A303 Amesbury to Berwick Down

8.6 Statement of Common Ground – Natural England

STATEMENT OF COMMON GROUND – Natural England

Version	Date	Status of Version
Rev 0	03.05.2019	Deadline 2 Issue

- ENVIRONMENTAL FUNCTIONS**
- EFA - Visual Screening
 - EFB - Landscape Integration
 - EFC - Enhancing the Built Environment
 - EFD - Nature Conservation & Biodiversity
 - EFE - Visual Amenity
 - EFF - Heritage
 - EFG - Auditory Amenity
 - EFH - Water Quality

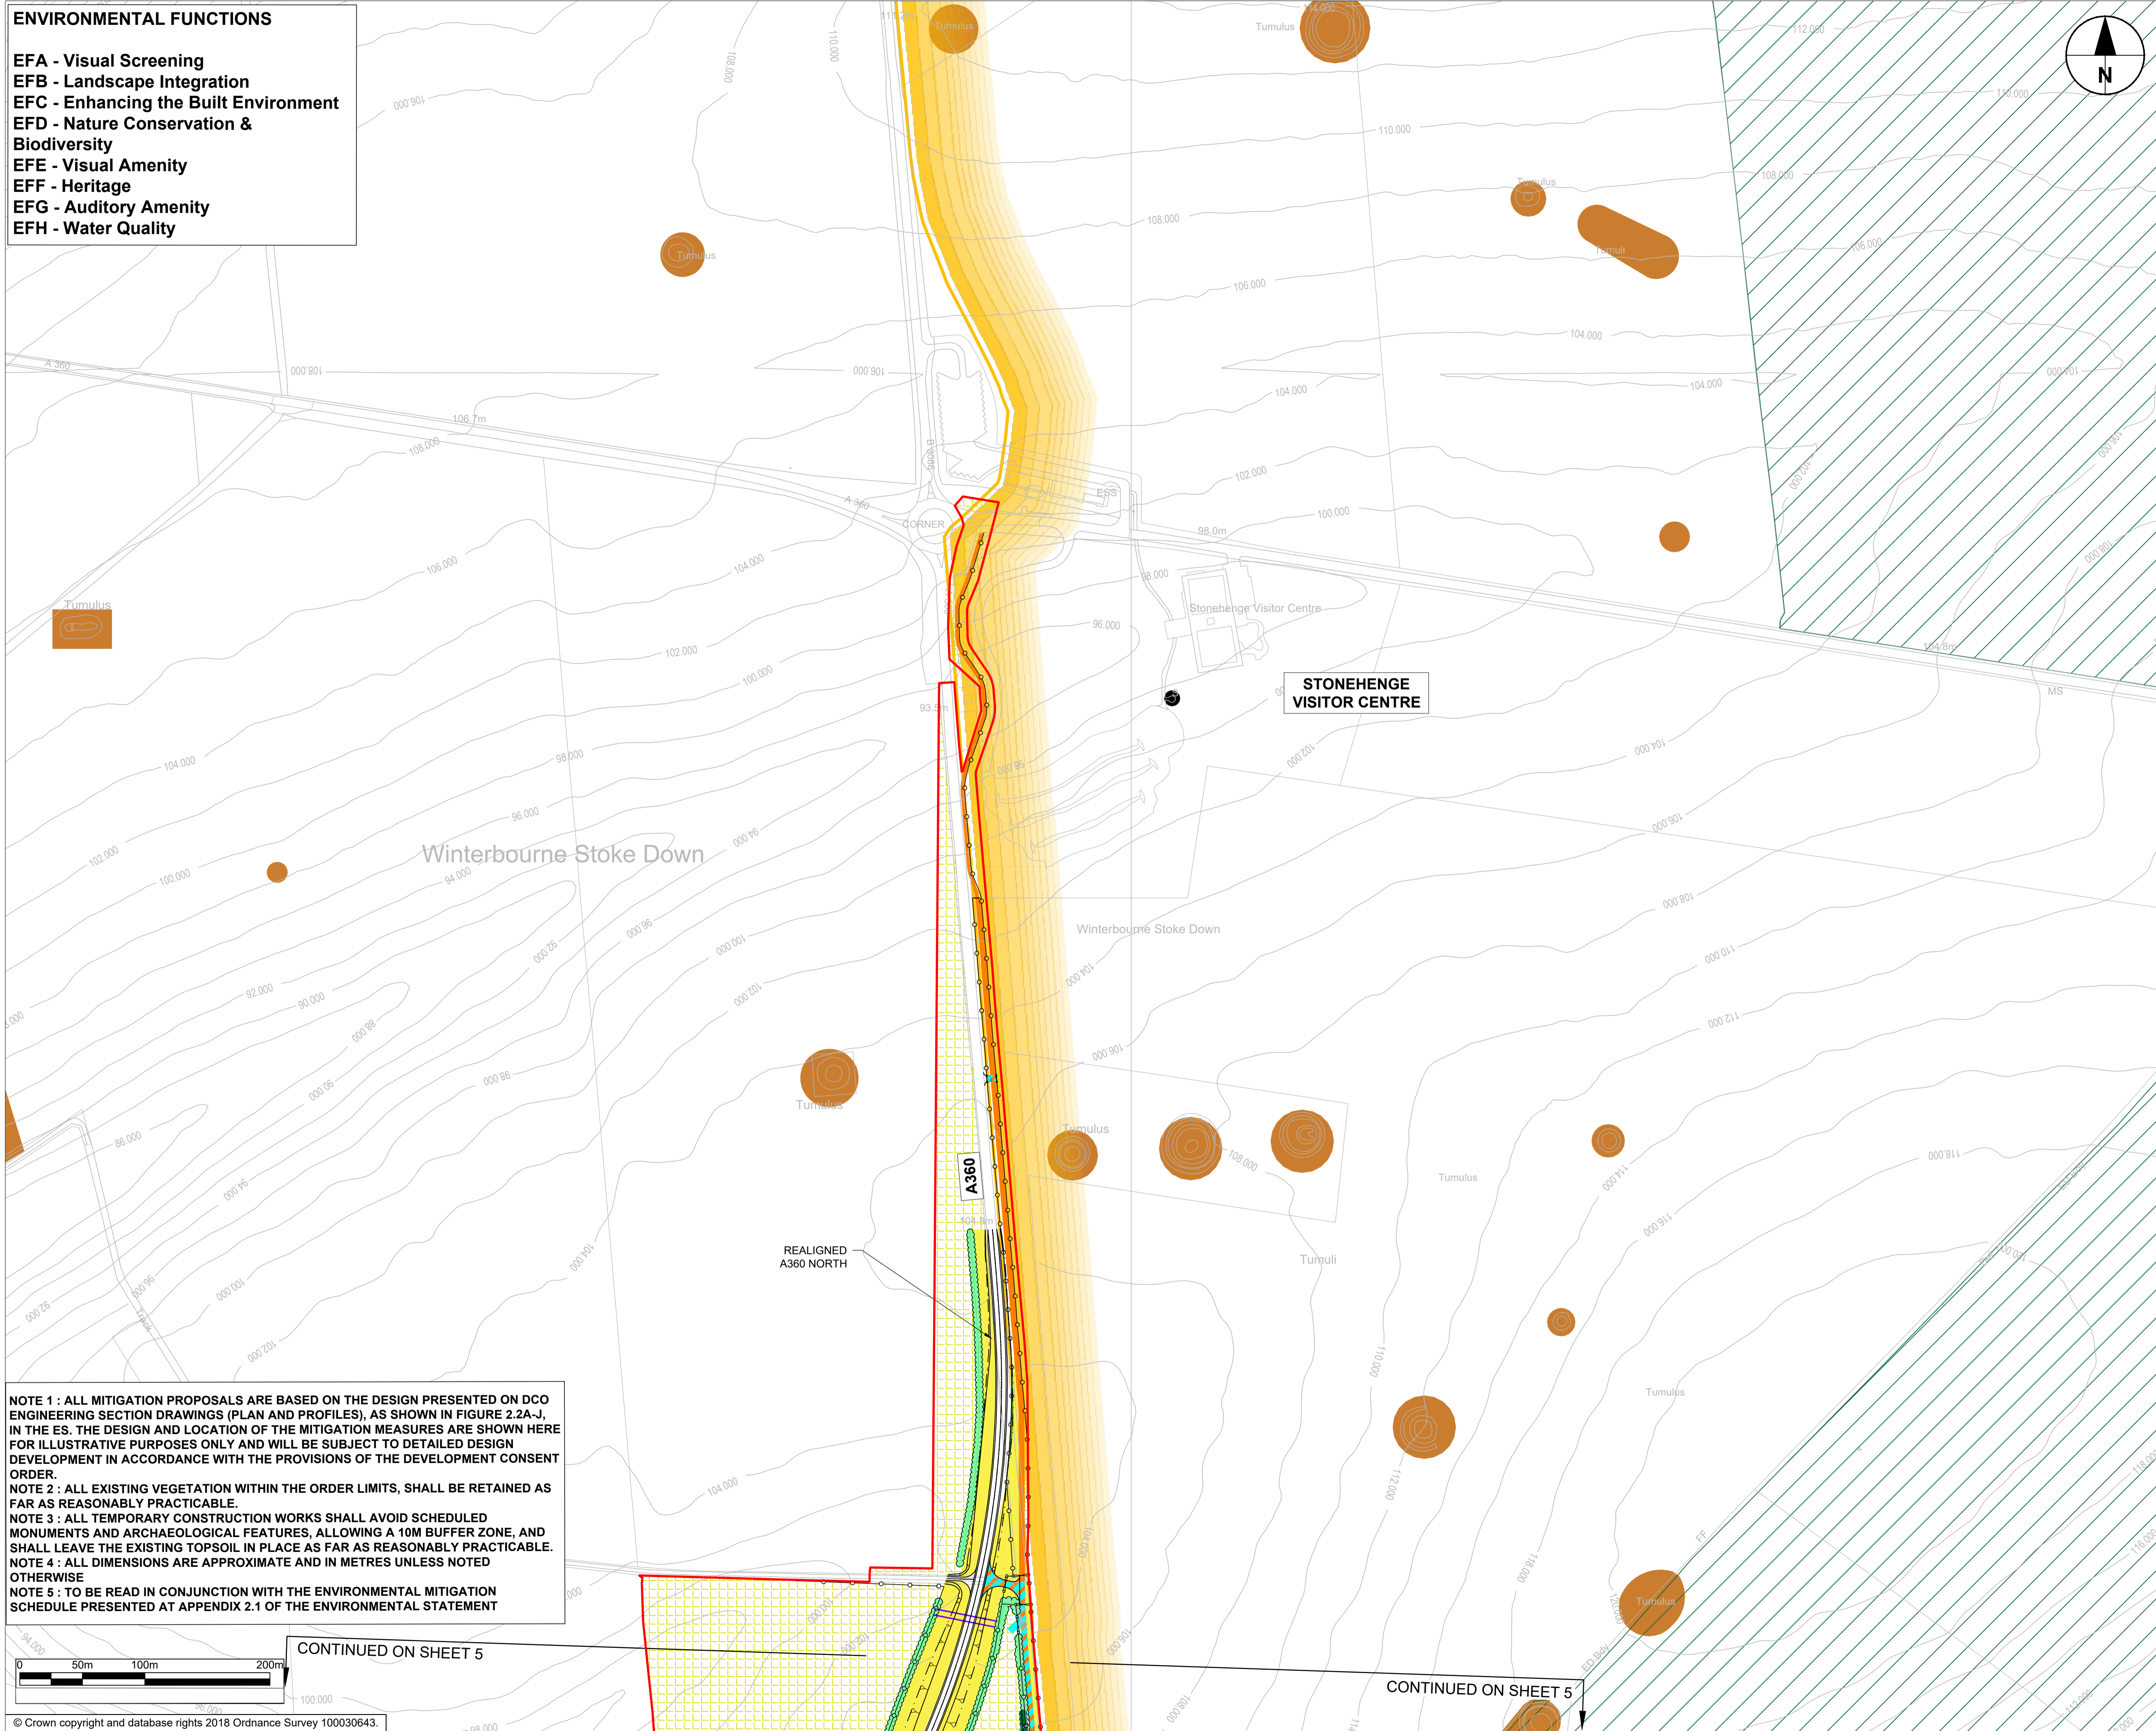
4.2	Environmental Statement Chapter 8 Biodiversity [APP-046]	Paragraph 8.9.71	Embedded mitigation Fencing	<p>We advise that the public right of way and Private Means of Access (PMA) route west of Green Bridge One is separated from the species rich chalk grassland to the north. Lack of fencing is likely to cause significant difficulties</p>	<p>Specific stock-proof fencing has been included within discrete areas and in locations associated with mitigation fencing.</p> <p>In the areas where chalk grassland is to be managed by grazing,</p>	Under Discussion

<p>due to conflict between dogs (and their owners) and stock management. Having the right establishment and management regimes for both these areas will be critical. Natural England is continuing to advise Highways England on the OLEMP.</p>	<p>appropriate access for stock, fencing and stock watering facilities would be provided, as described in ES Chapter 8, Biodiversity [APP-046], 8.9.71.</p>
